CITY OF ALBUQUERQUE

**RE: Los Pastores Shopping Center & McDonalds
Montgomery/Wyoming
DMP Addendum 3
Engineers Stamp Date: 3/26/2019,
Hydrology File: F19D013C & F19D013A**

Based on the information provided in your submittal received on 3/26/2019 the DMP Addendum cannot be approved until the following comments are addressed.

**POST-DEVELOPMENT
DRAINAGE BASINS**

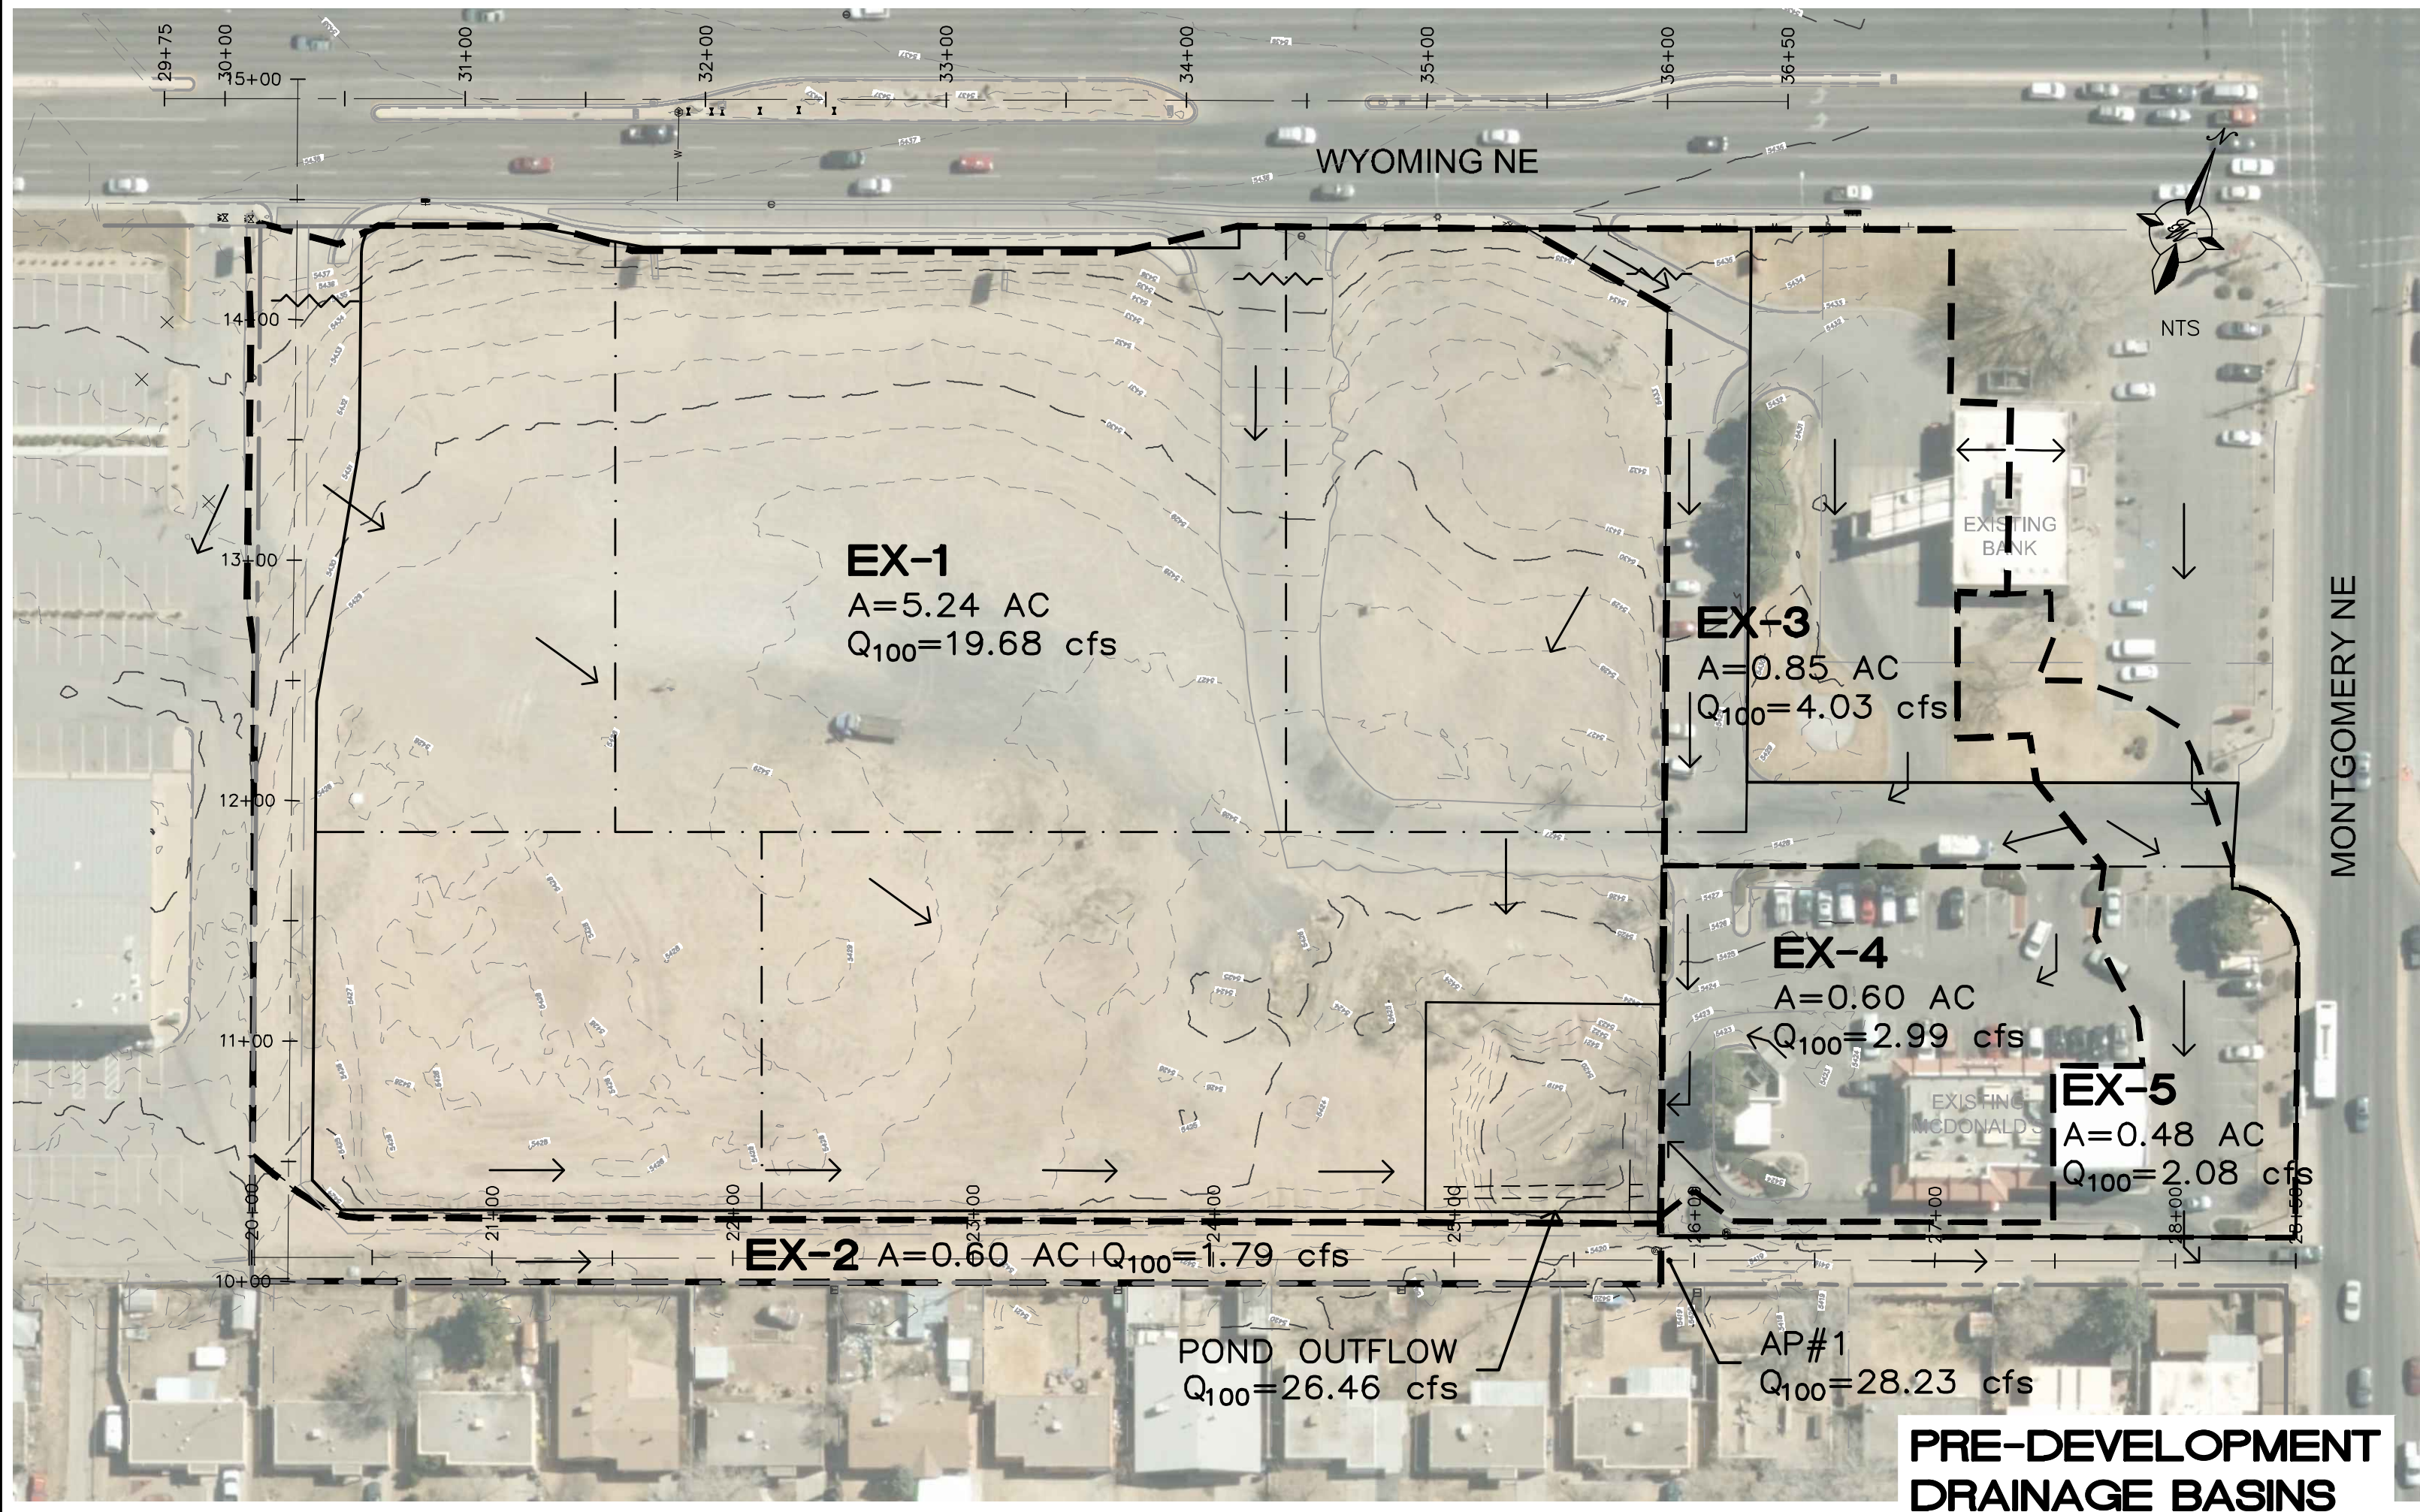
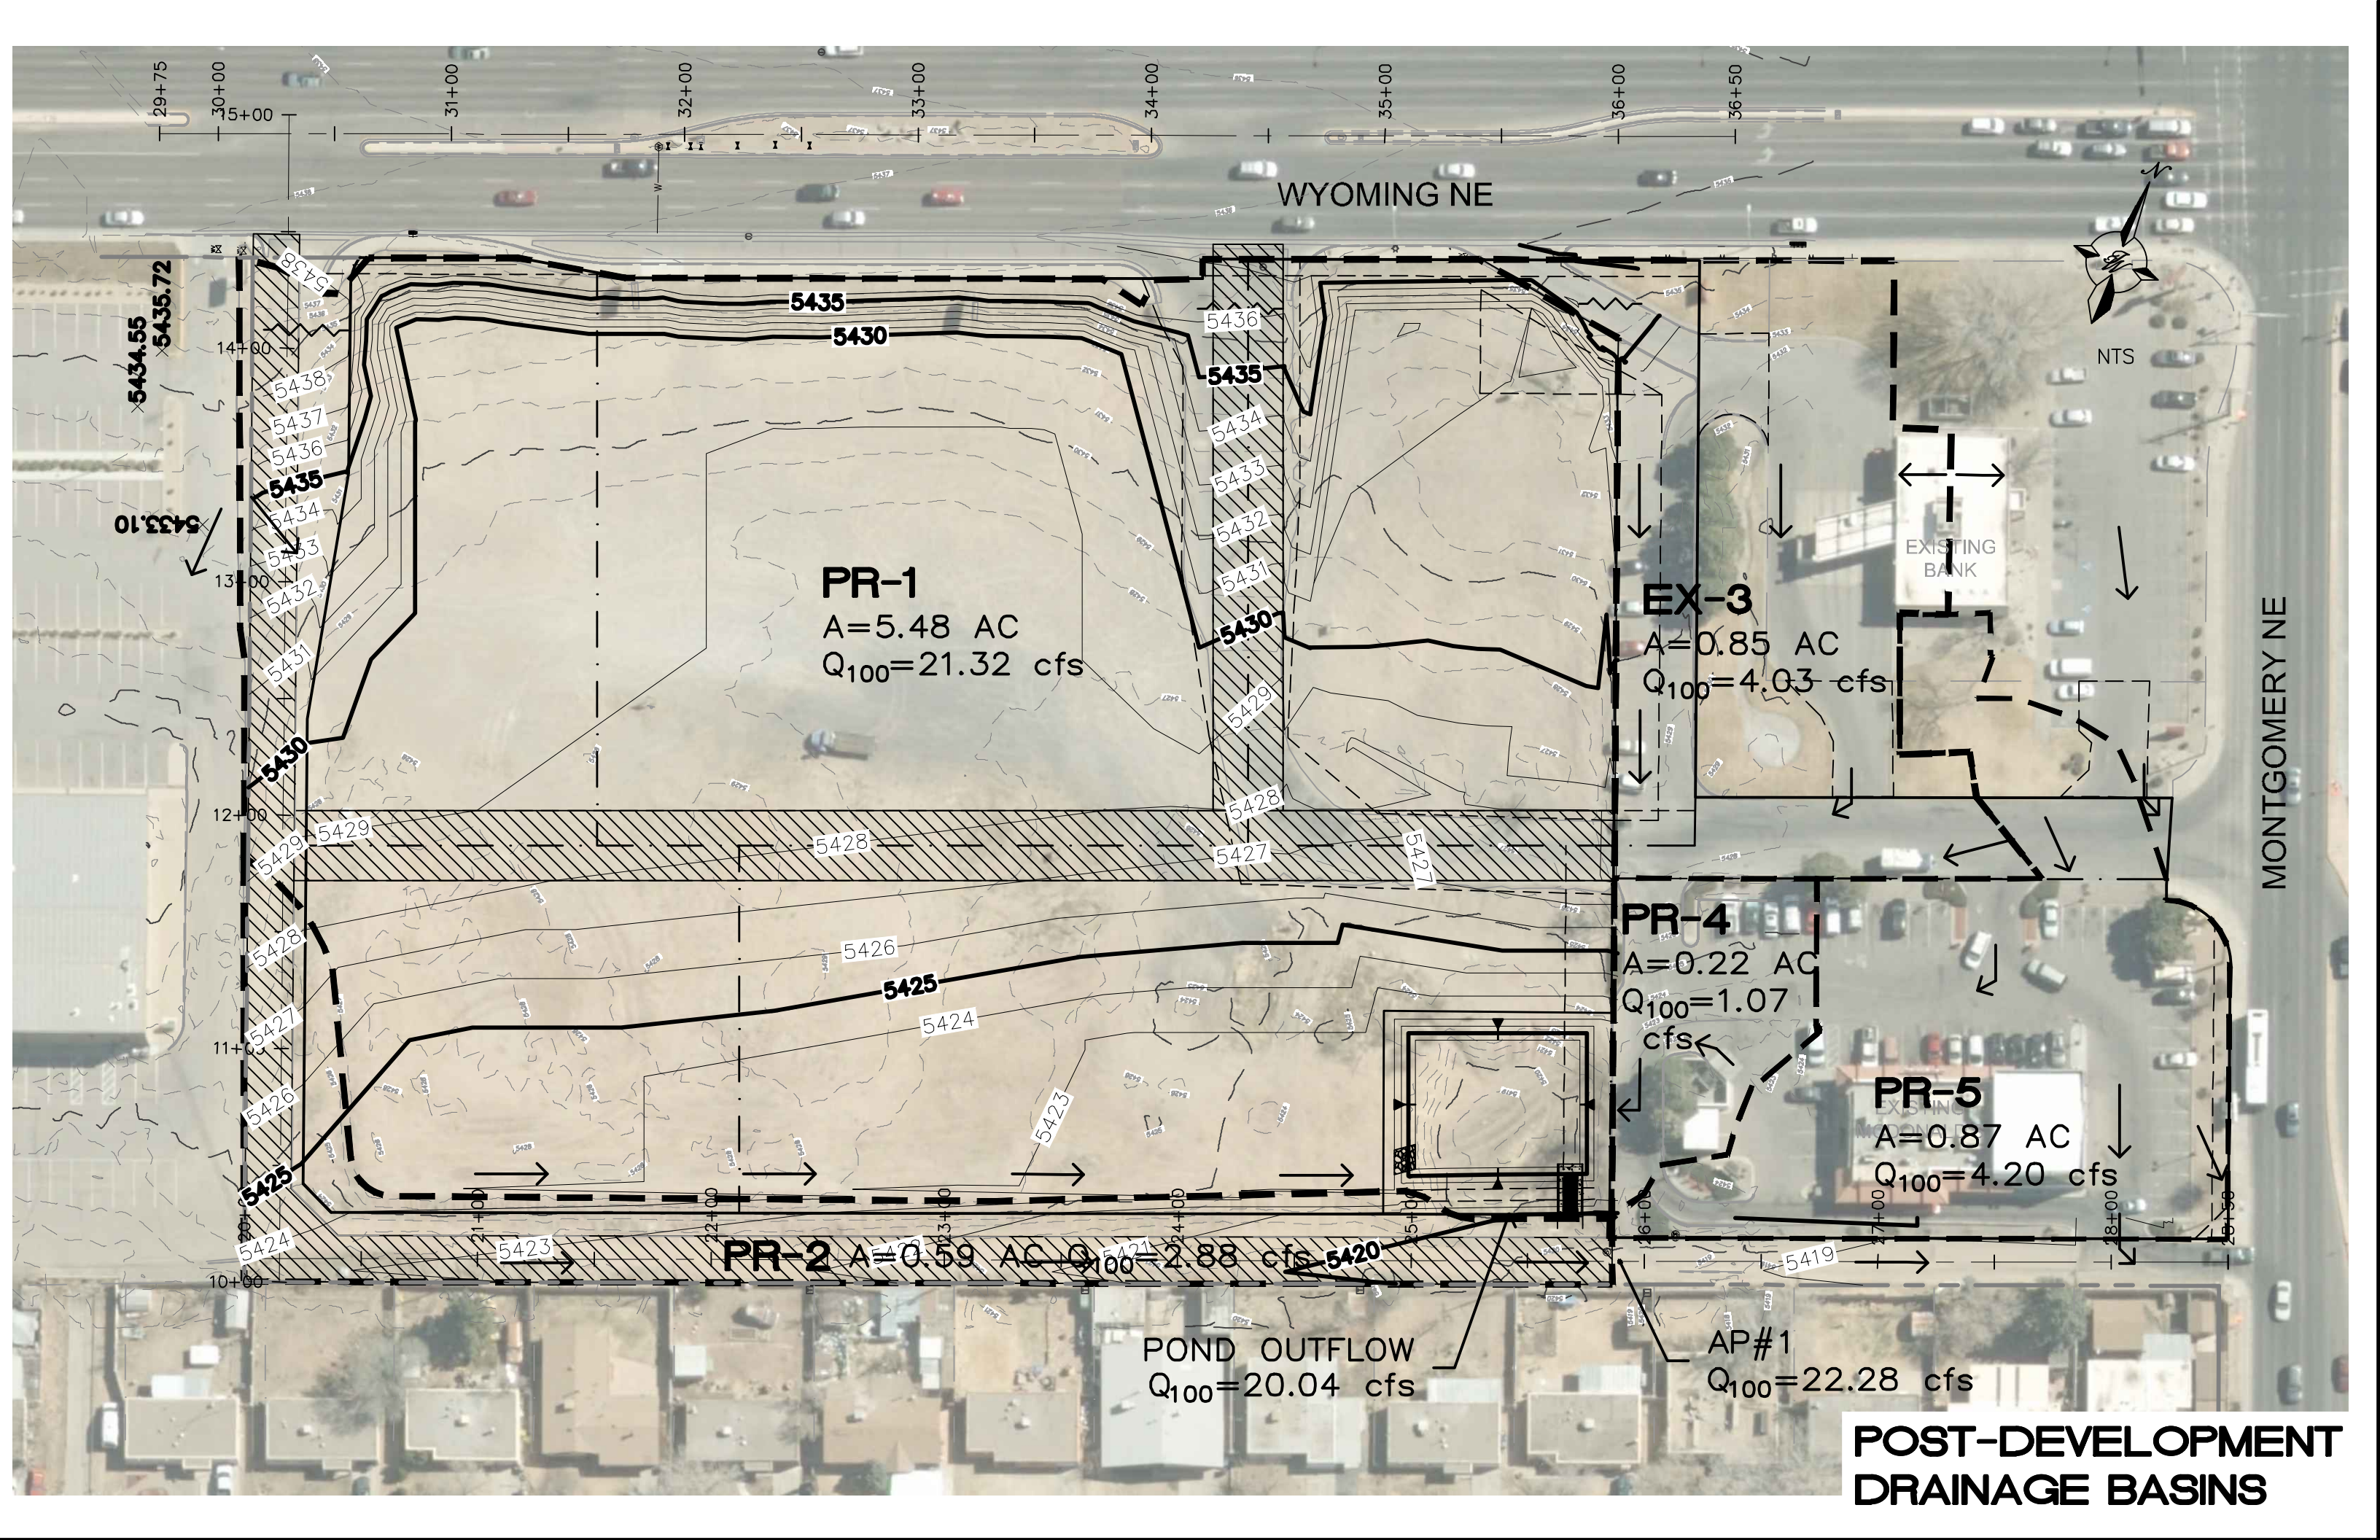
1. Why is the total area of the proposed condition different than the total area of the existing conditions? The total area in the basin Data Table and in the AHYMO should be the same for both Existing and Proposed conditions. The area for basin PR-4 is 0.22 acres in the AHYMO and on the Basin Map but 0.06 acres on the Basin Data Table. The basin Map should be to scale and have a graphic scale bar so the areas can be checked.

- c. Flow over spillway added by adding stage storage discharge for elevations above spillway.
5. Please explain what conditions are represented on the "Pre-development and Existing" basin map and the AHYMO file respectively. Please provide an explanation in the report of revisions to the previously approved analysis, specifically the addition of AP#2 and contributing basins. Correct the flow at AP#2
